RE: M/48/26/HH- Request for additional information.

Proposed Car Port Planning
Date January 2026
Scale 1:200 1:1250

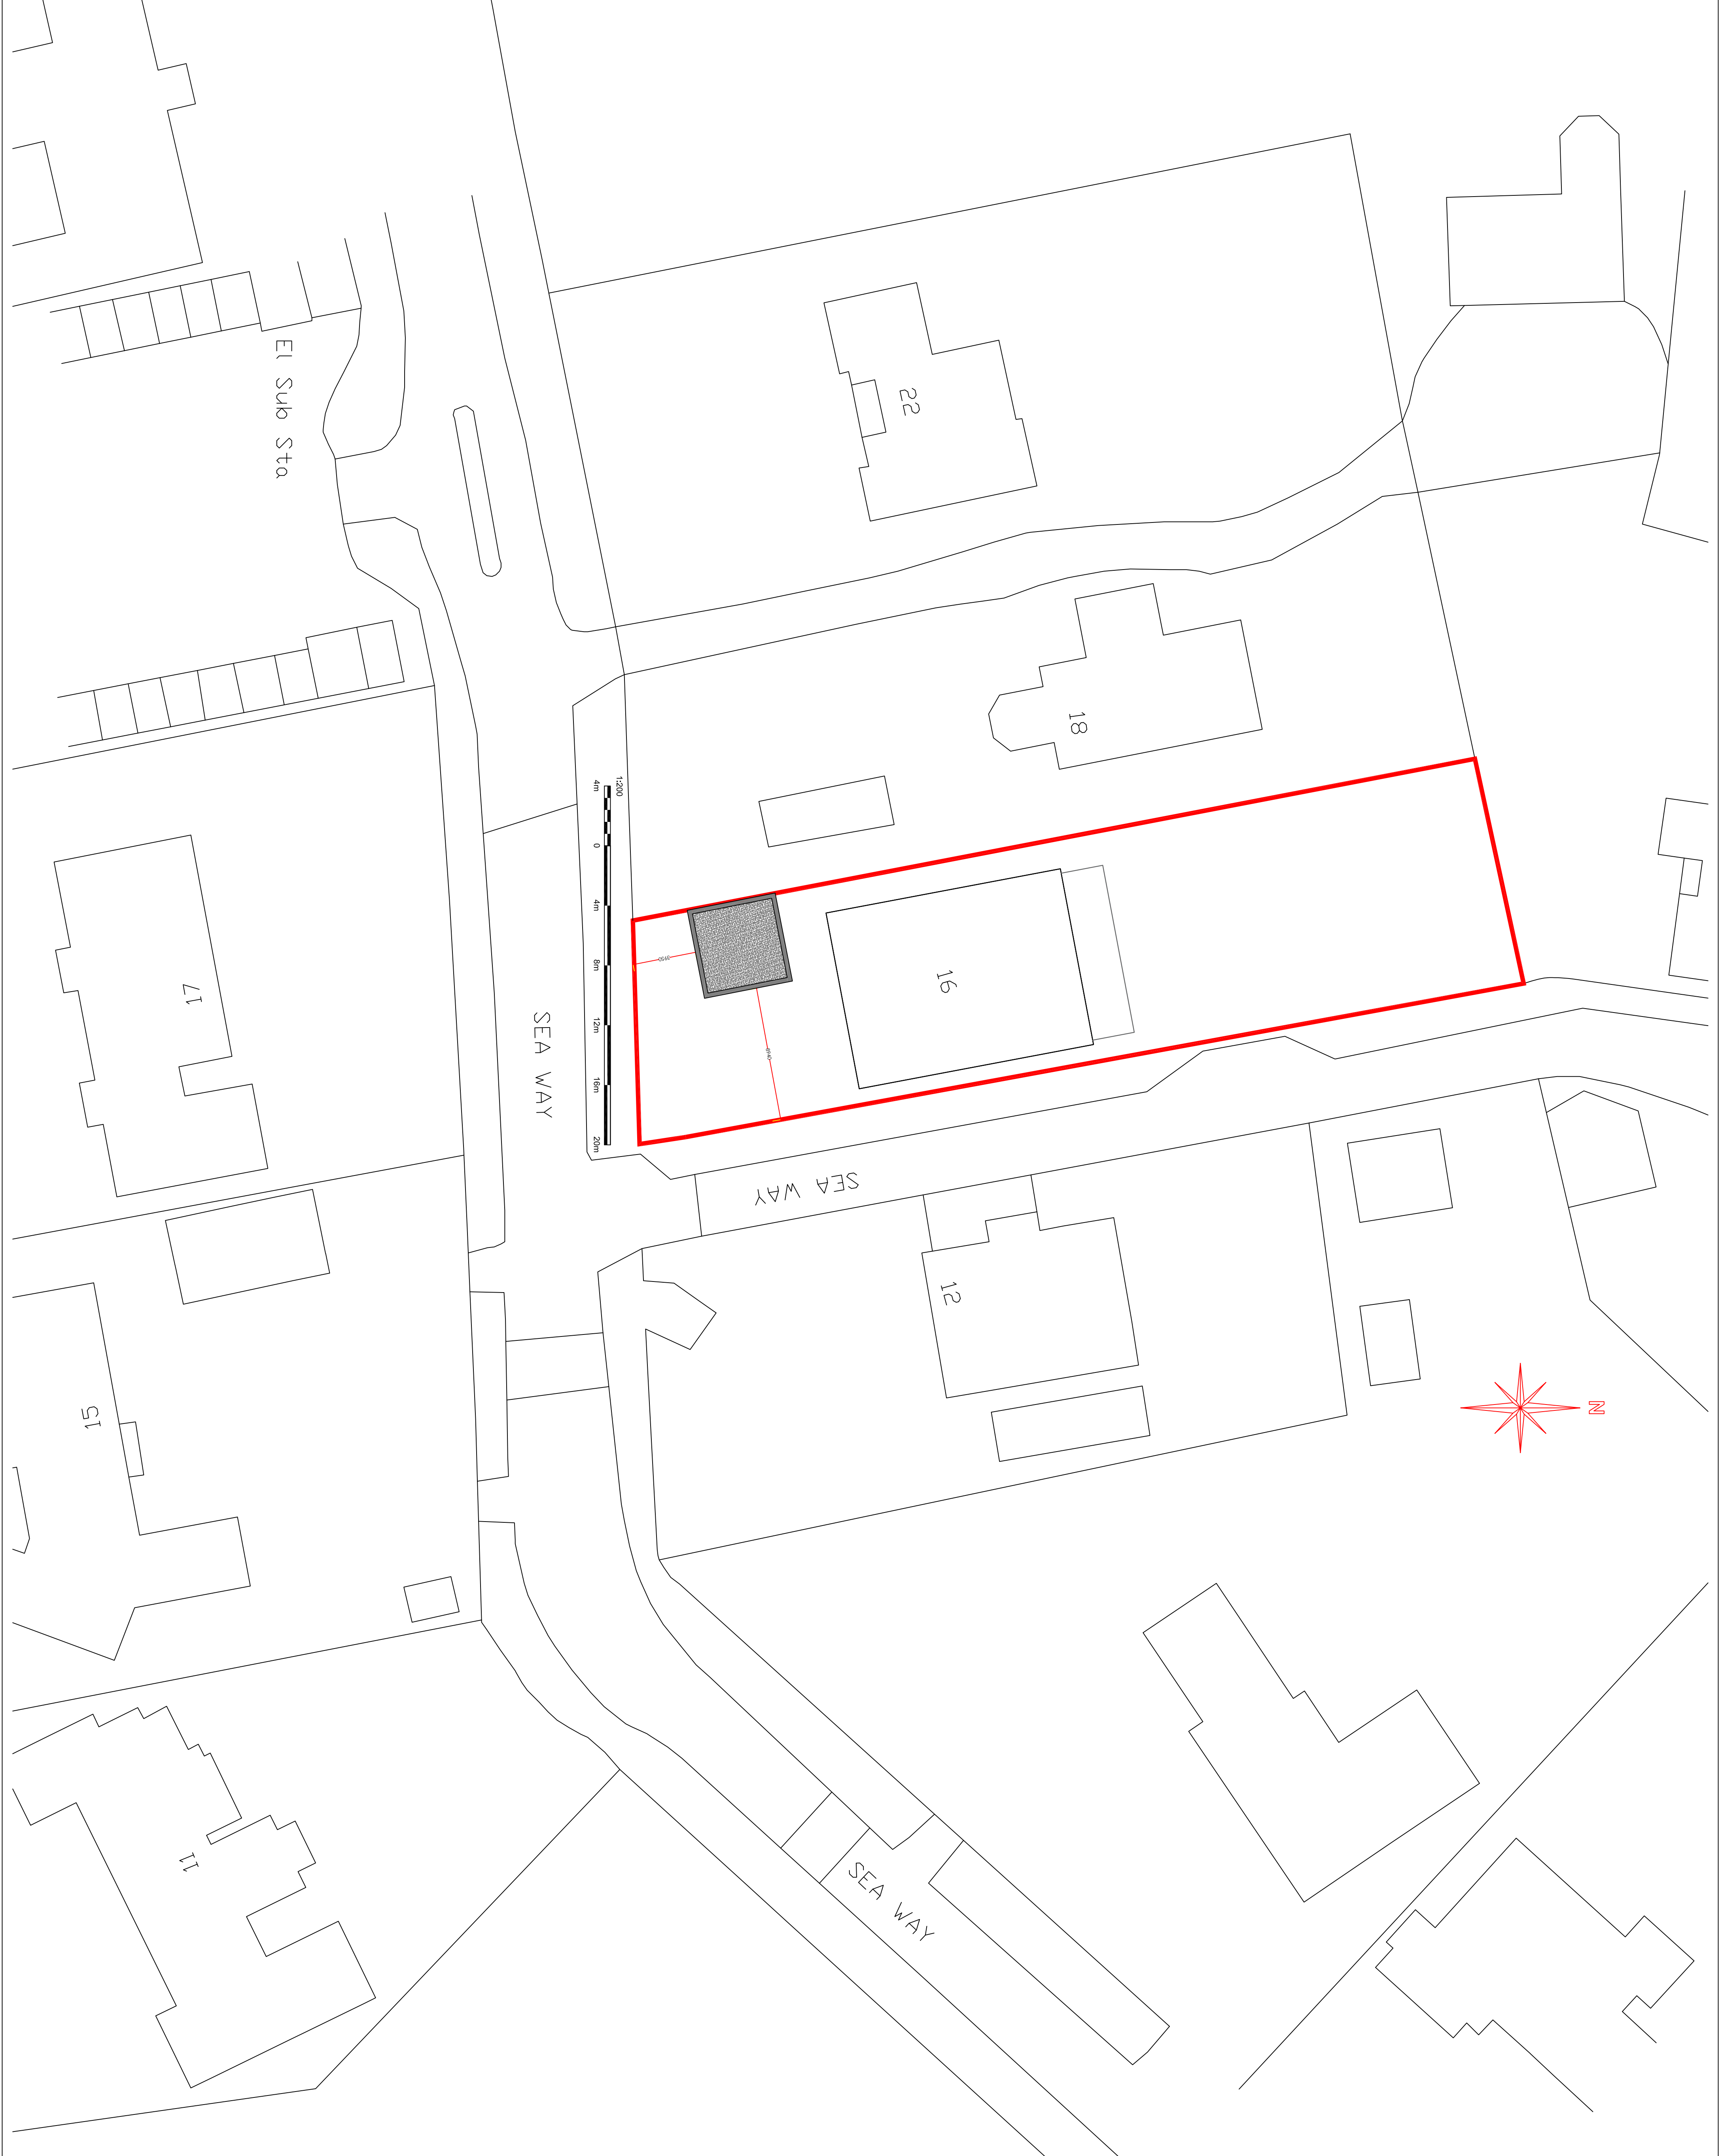
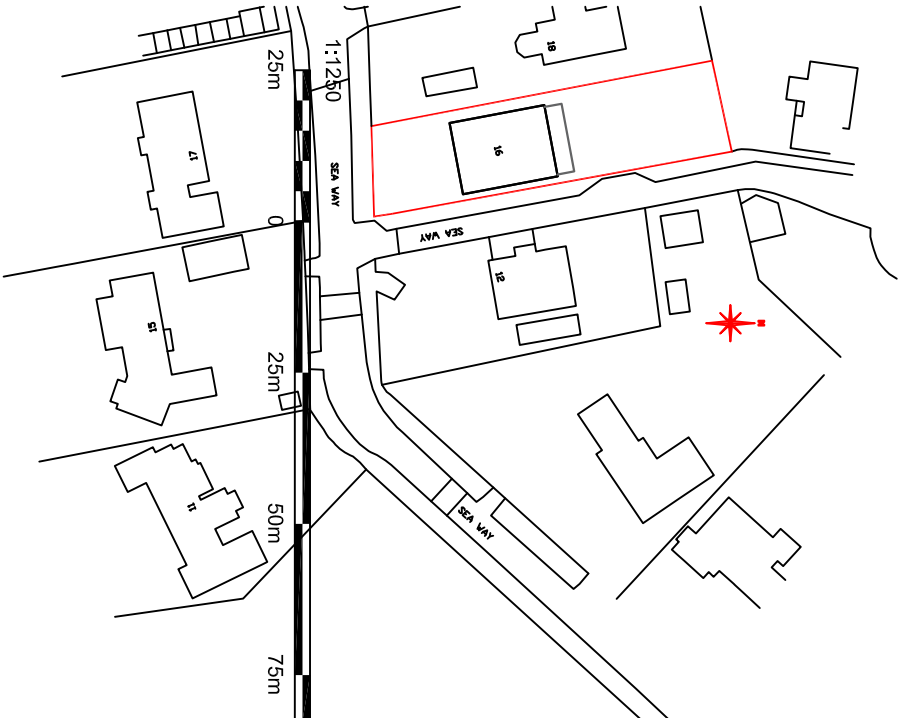
We require scale bars on location and block plans so that we can measure the dimensions of the dwelling to ensure they are consistent across the other plans.

Please could the location plan (needs to be existing) have a scale of 1:1250, and the block plan (needs to be proposed) have a scale no larger than 1:500.

The proposed North and south plan has a smaller plan to the side, the given 1:1250 scale of this plan is not consistent with the provided scalebar.
